# BEACON FEN ENERGY PARK

Planning Inspectorate Reference: EN010151

Statement of Common Ground (Draft) with North Kesteven District Council  
Document Reference: 8.2  
February 2026

Appendix 3 – Permissive pathway indicative route

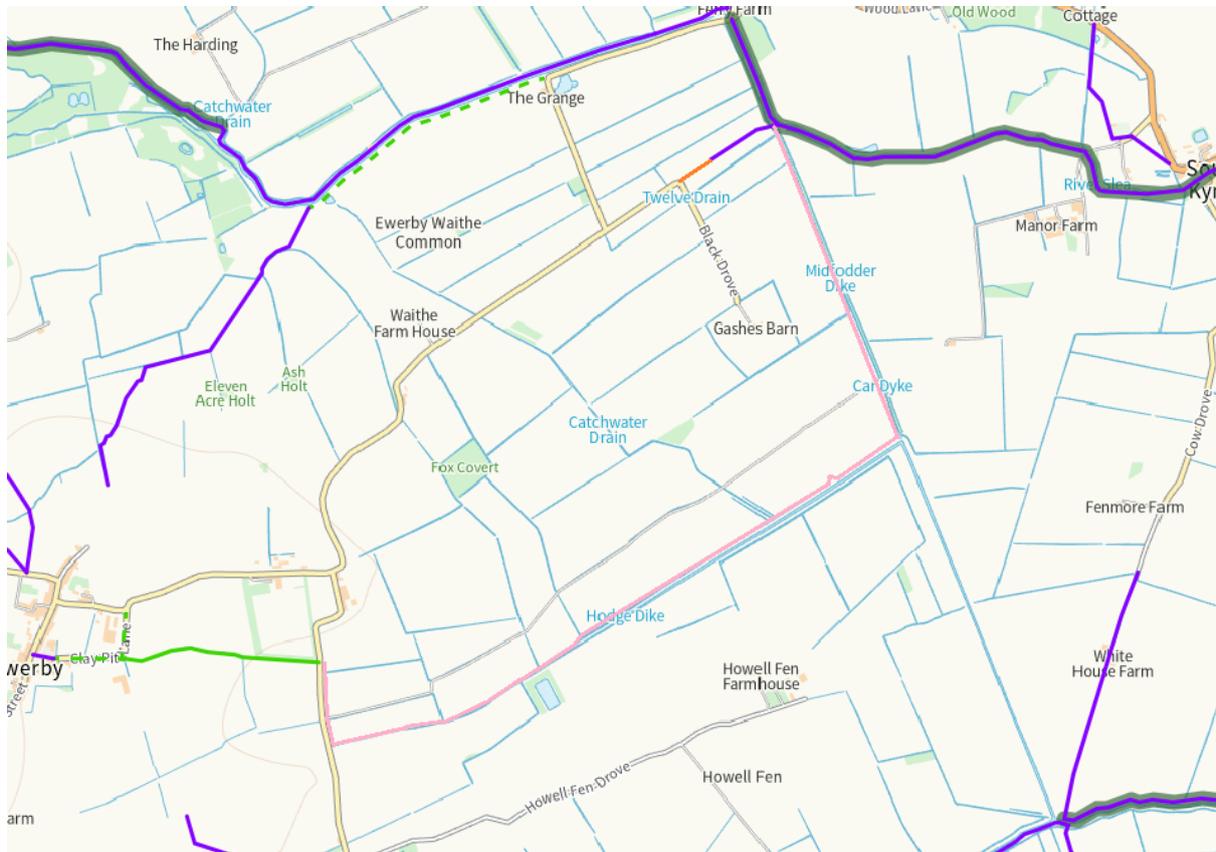
- 1.4.10 PRoW Ewer/12/1 is being extended in a south and westerly direction as a permissive path terminating in the vicinity of Ewerby Thorpe, and will be in place for the operational duration of the Proposed Development. The exact route of the permissive path will be determined via the discharge of requirement in the **Draft DCO (Document Ref: 3.1)**, but it is anticipated to run in a south easterly direction along Car Dyke and then heading south west on the north side of Hodge Dike. An undetermined number of footbridges (unlikely to be more than 8 in number) to cross existing watercourses will be required and will require the usual water course crossing agreements to be sought with the relevant Internal Drainage Board in parallel with the discharge of the requirement.

Appendix 1a – Soil Stockpiles Indicative Cross Sections

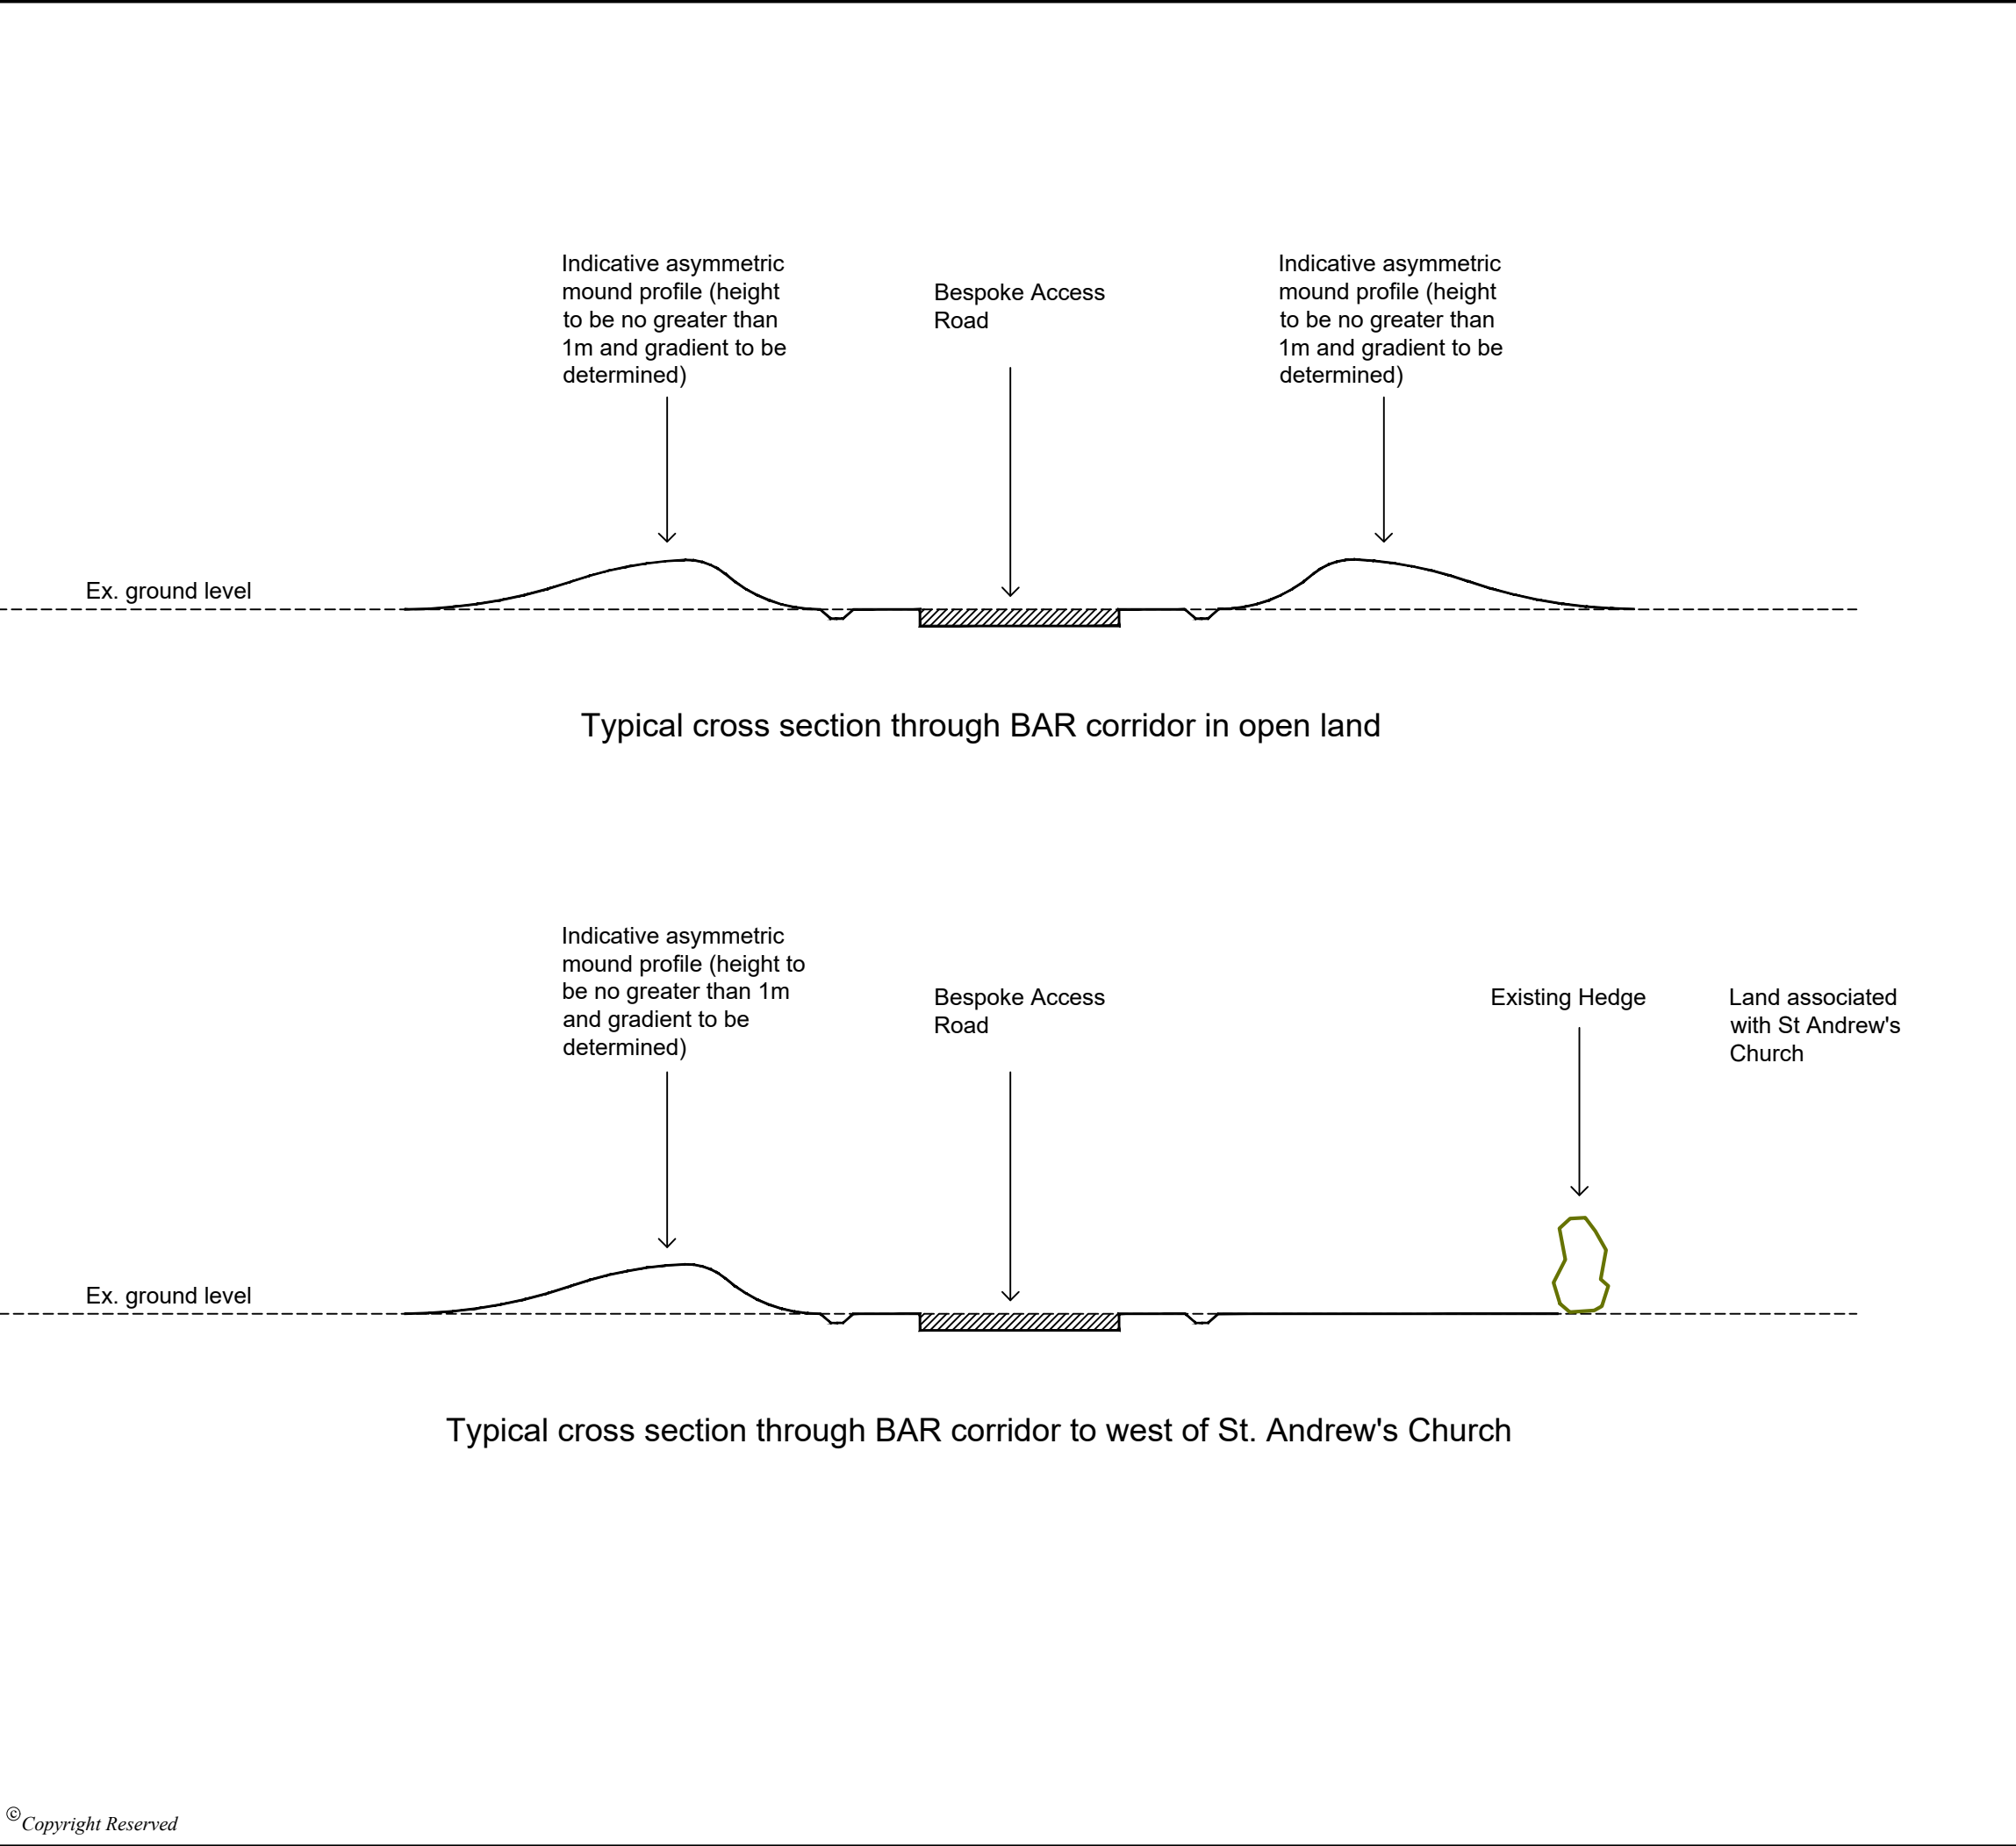
#### **Soil Stockpiles within the BAR:**
